**WELWYN HATFIELD BOROUGH COUNCIL
EXECUTIVE DIRECTOR - PLANNING, PUBLIC PROTECTION AND GOVERNANCE**

Application No: 6/2017/0446/HOUSE
Location: 22 Stanborough Road Welwyn Garden City AL8 6XD
Proposal: Erection of first floor side extension
Officer: Mrs S Smith

Recommendation: Refused

Drawing No: 4046-P01 Revision:

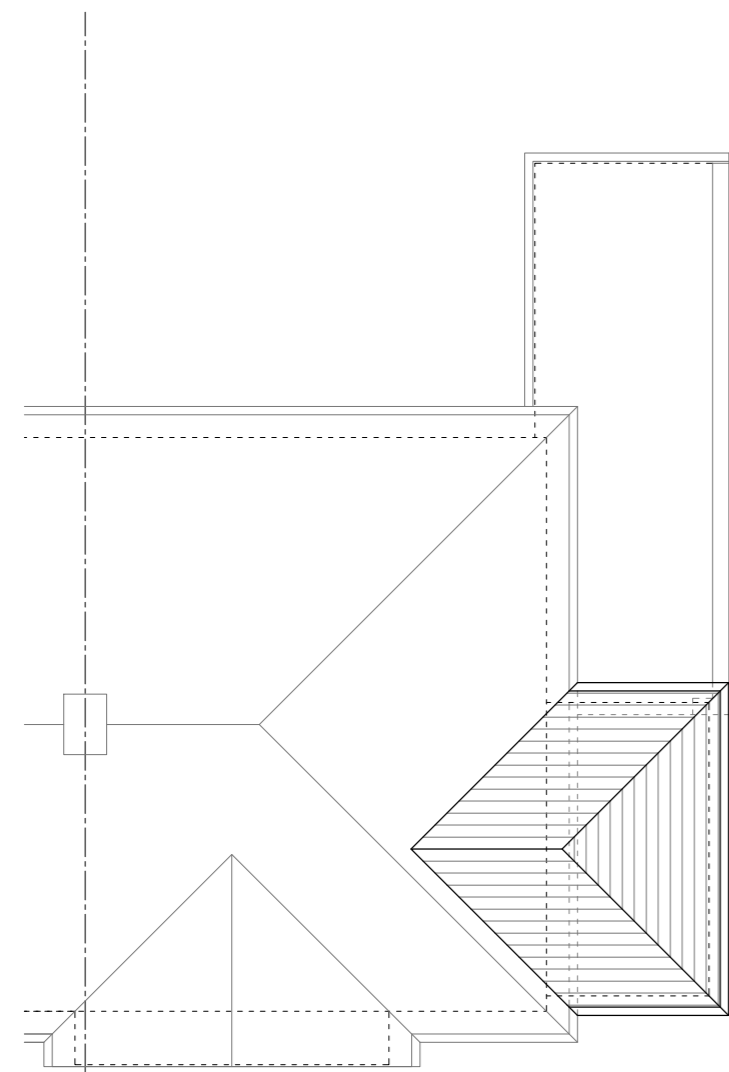
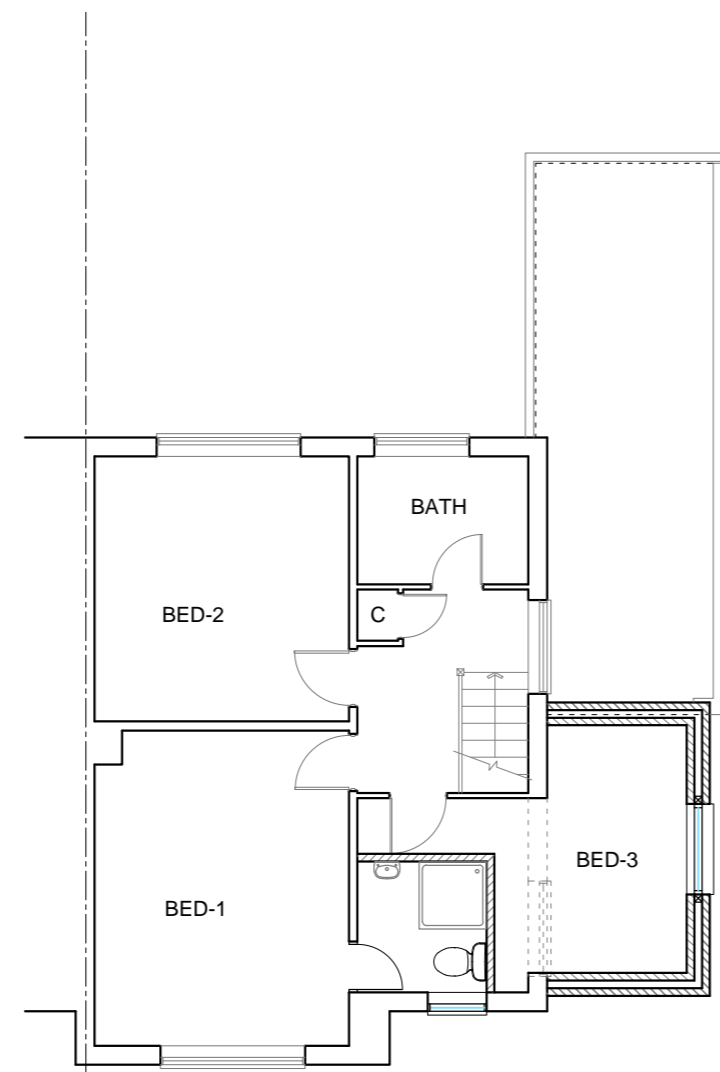
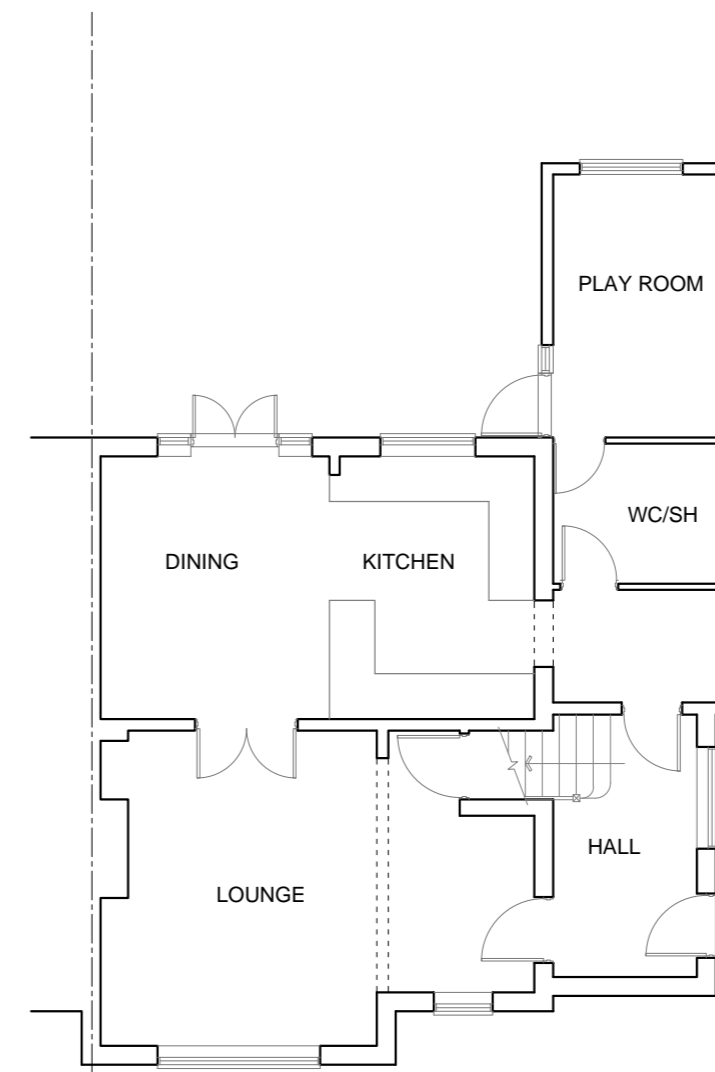
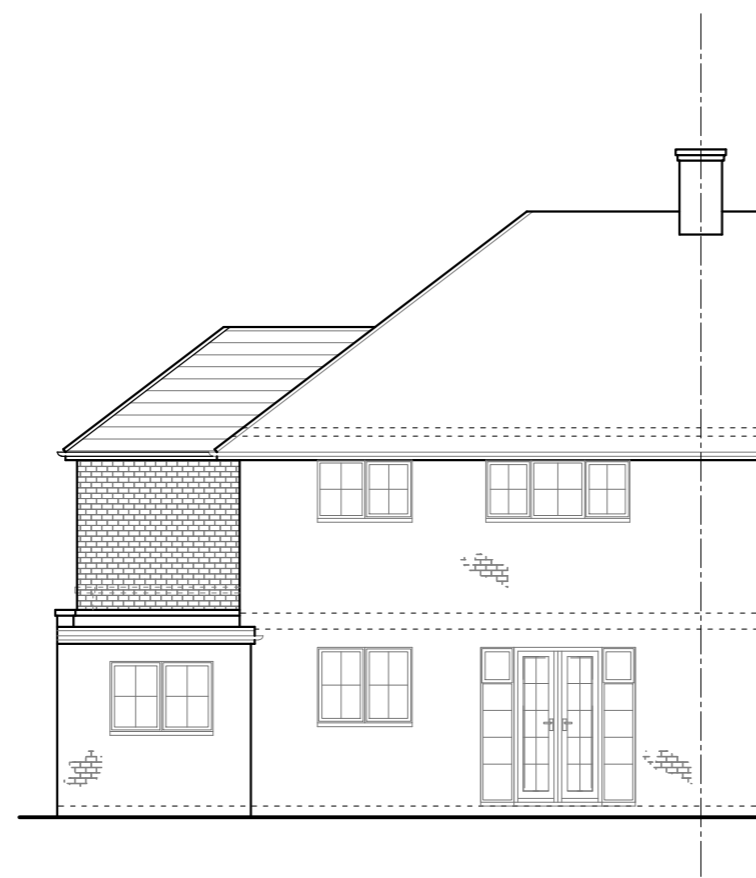
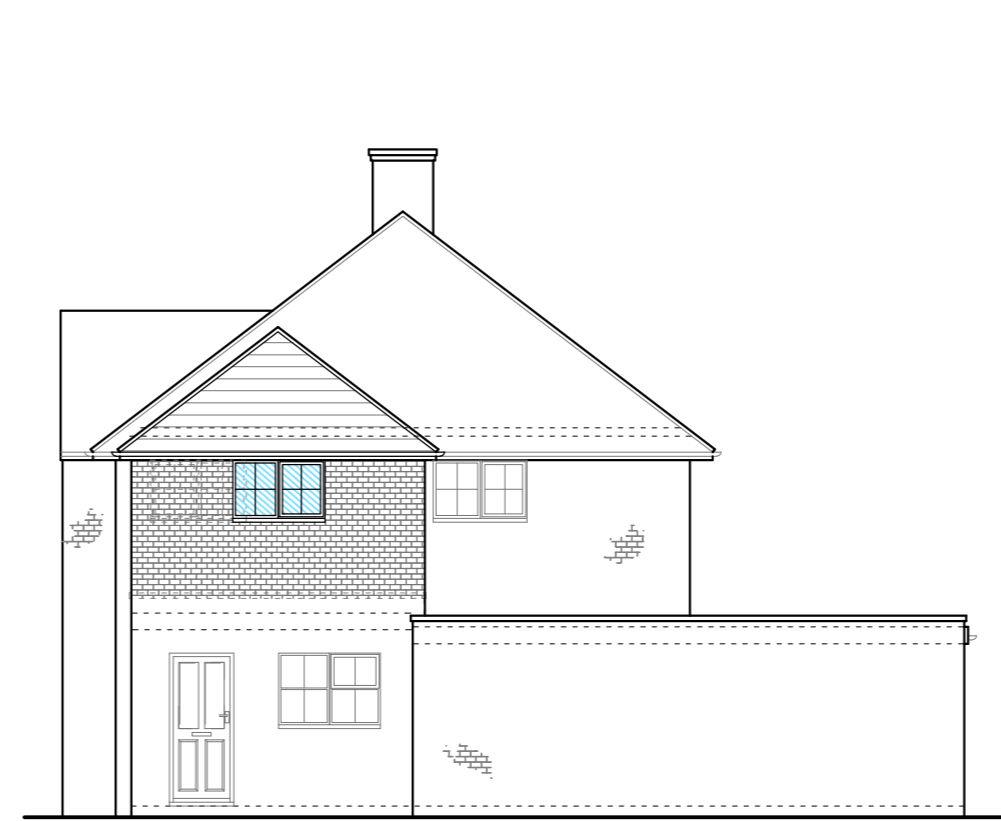
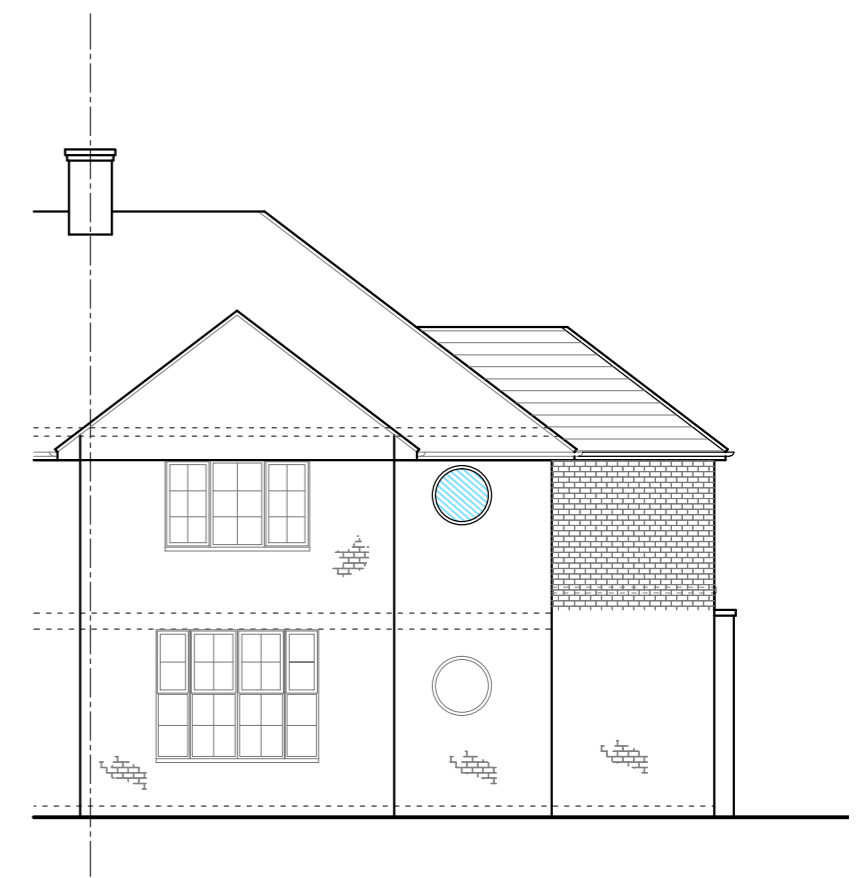
1. By virtue of the location, design and appearance of the proposed extension it would appear as an incongruous addition to the application property and to the row of terrace dwellings. Whilst the proposed development would lead to less than substantial harm to the character and appearance of the Central Welwyn Garden City Conservation Area, the harm is not outweighed by any public benefits. The proposal therefore represents poor quality design contrary to Policies D1 and D2 of the Welwyn Hatfield District Plan 2005, Supplementary Design Guidance of the Welwyn Hatfield District Plan 2005 and the National Planning Policy Framework.
